This project is a request for a mini-warehouse as a Special Use in the CC zoning district with a new concurrent SDP.

PCD File: PPR2412 (please add to all files)

RE: MyGarage @ Northcrest – 2510 Canada Dr. Site Development Plan Amendment, Special Use

SITE DEVELOPMENT PLAN
EL PASO COUNTY, COLORADO.

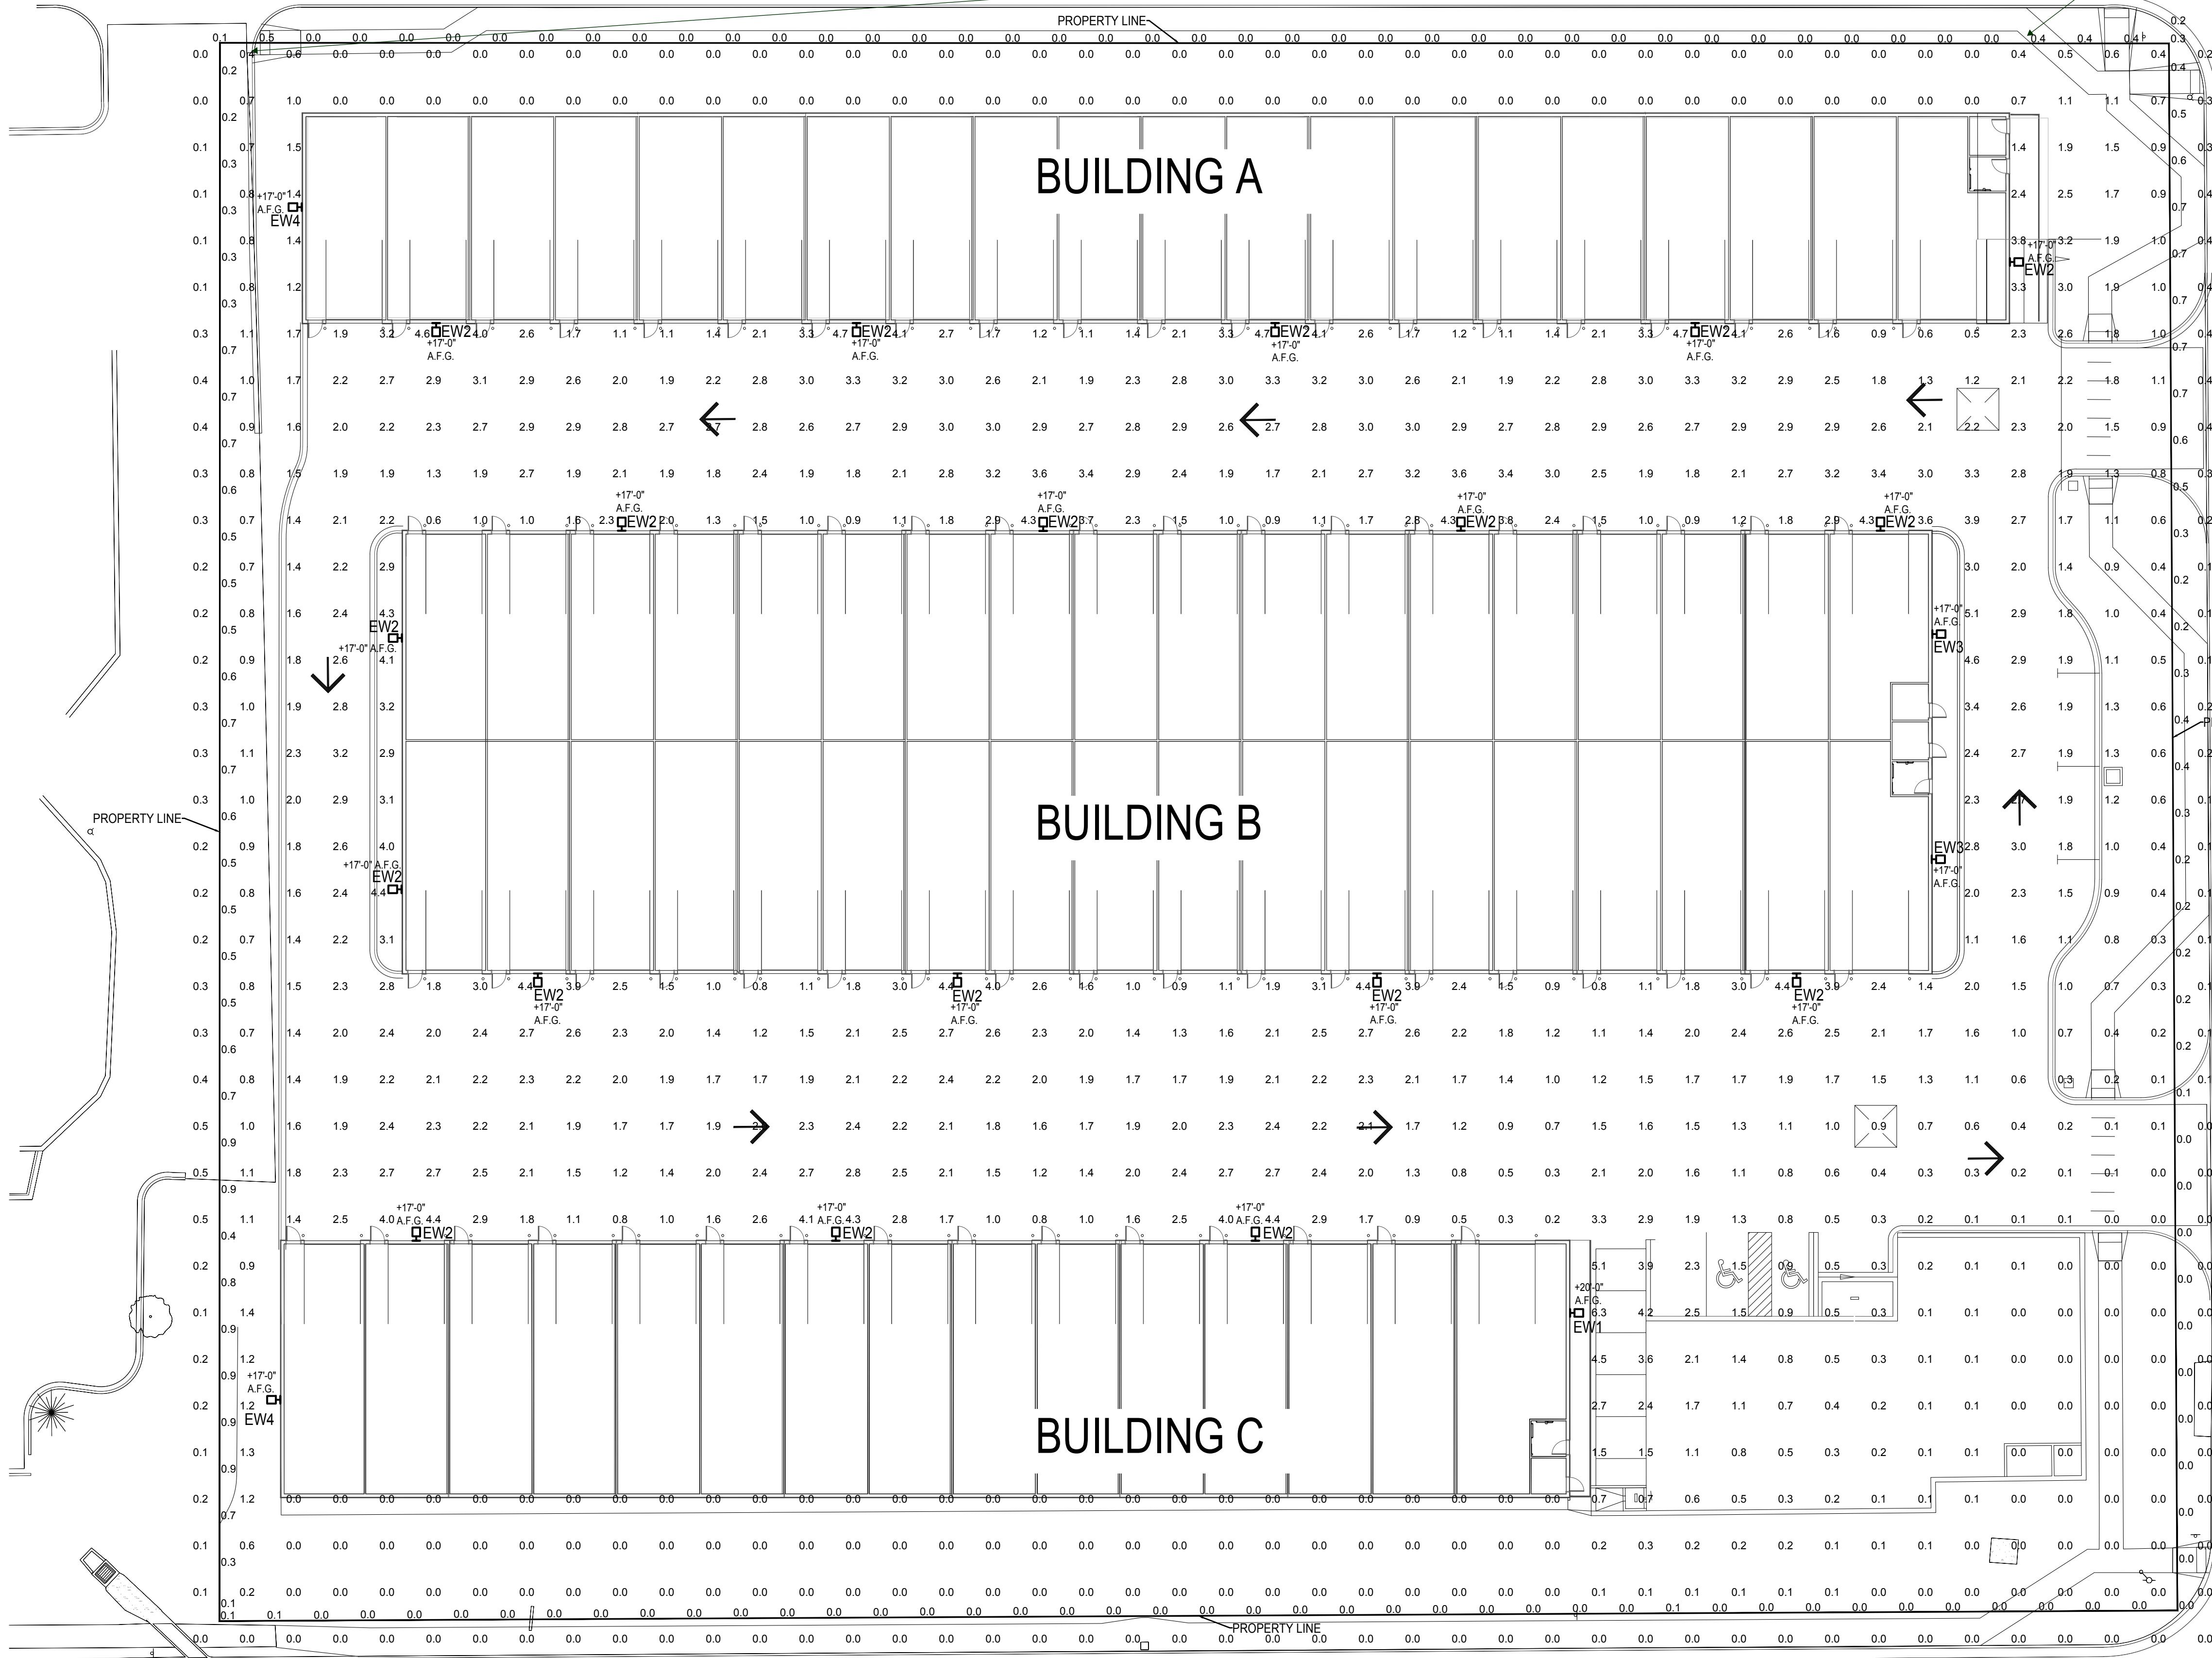
(An entirely new SDP has been submitted. Please review.)

Explain controlled access or lack thereof. SDP shows no controlled access with gates typical of a self storage type business. Also units have water and power in them and common area bathrooms.
